From: Brian Holland
Sent: 05 September 2011 17:42
To: Planning.Responses
Subject: RE: Planning Consultation on: EG/33/11/
Engineer's Response

APPLICATION EG/33/11/
NO:

Registered: 20-JUN-11
Site Greenoaks Barnham Road Barnham PO22 0EB
Address:

Description of Works: Proposed redevelopment of land to provide 13 no. new dwellings to include 4 no. 2 bed houses, 6 no. 3 bed houses, 1 no. 4 bed house & 2 no. 5 bed houses. Together with associated access, car parking, landscaping & retention of existing property.

RBA 895 - 50 P8

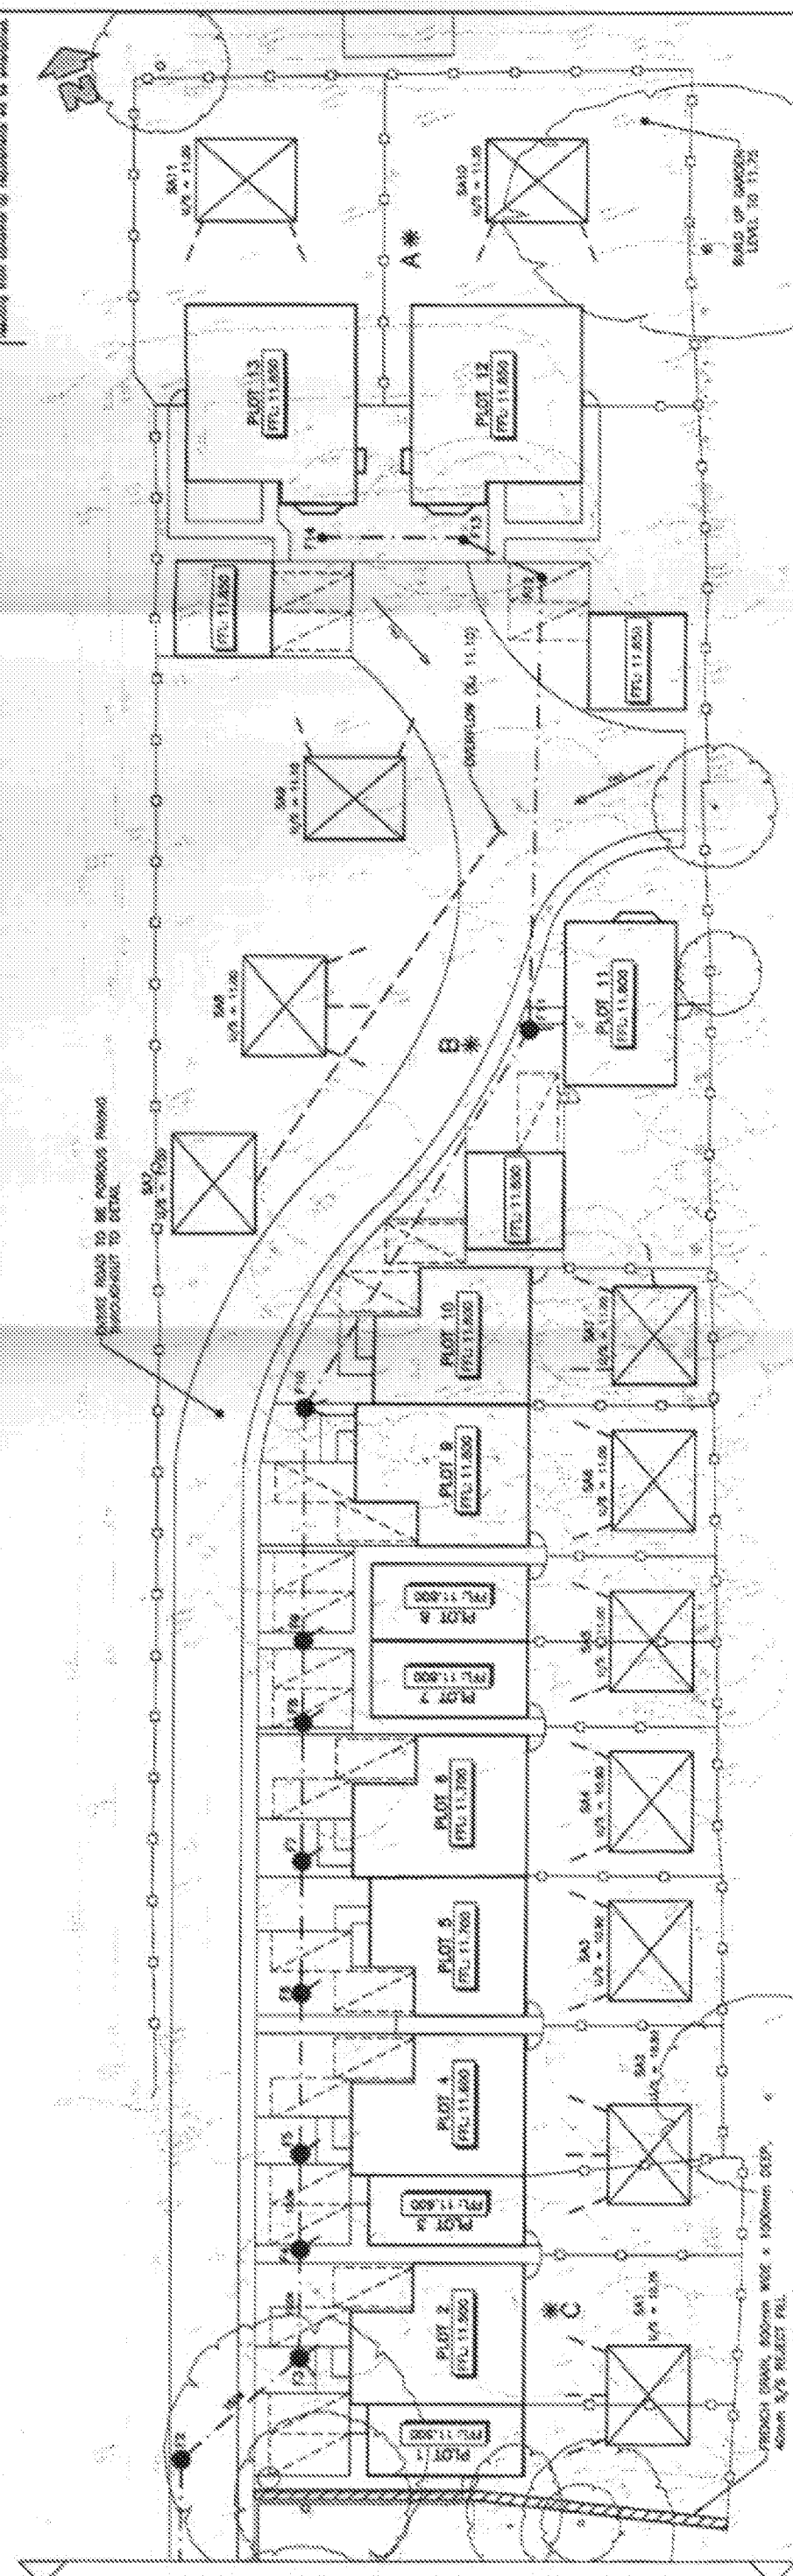
There are not adequate details of the soakaway designs provided. It is apparent that the top of the soakaways must be near or at ground level. It will therefore be necessary to take into account the rainfall that also lands on the area of the soakaway itself as this will also be contributing to the input flow into the soakaway. The area of the surface of the soakaway should therefore be added to the impermeable area that is being fed into the soakaway to give a total area for which the soakaway needs to be designed.

Some of the areas feeding into the individual soakaways appears to be in excess of the impermeable area of 75m² used in the design. It is also not clear from drawing no. RBA895/50 Rev P6 which areas drain into which soakaways, particularly at the northern end of the site. In the variable circumstances that exist on this site, designs should be submitted for each individual soakaway and also permeable pavement/driveway areas. It is possible that any excess water at the southern end of the main driveway would flow onto the existing public highway rather than into the overflow soakaway proposed at the higher end of the new road. The permeable pavement may require construction in self contained zones to ensure utilisation of all storage capacity due to the longitudinal gradient of the road. The use of 100% void ratio for the design of the soakaways is also a concern, details of the construction would be required to confirm this.

Also, due to the proximity of the top of the rectangular pit soakaways to the ground level, the garden area in which the soakaways are sited would need to be permanently devoid of any planting and designated as a 'no dig zone' to avoid damage to the soakaway structure and possible reduction in future storage capacity. They would probably require covering with a permeable geotextile to ensure no infiltration of debris. Details of the proposed method of erecting fencing within the soakaway areas are also required to enable consideration of the impact of this on the soakaways function.

Further details of the proposed method of surface water disposal are therefore required for our consideration.
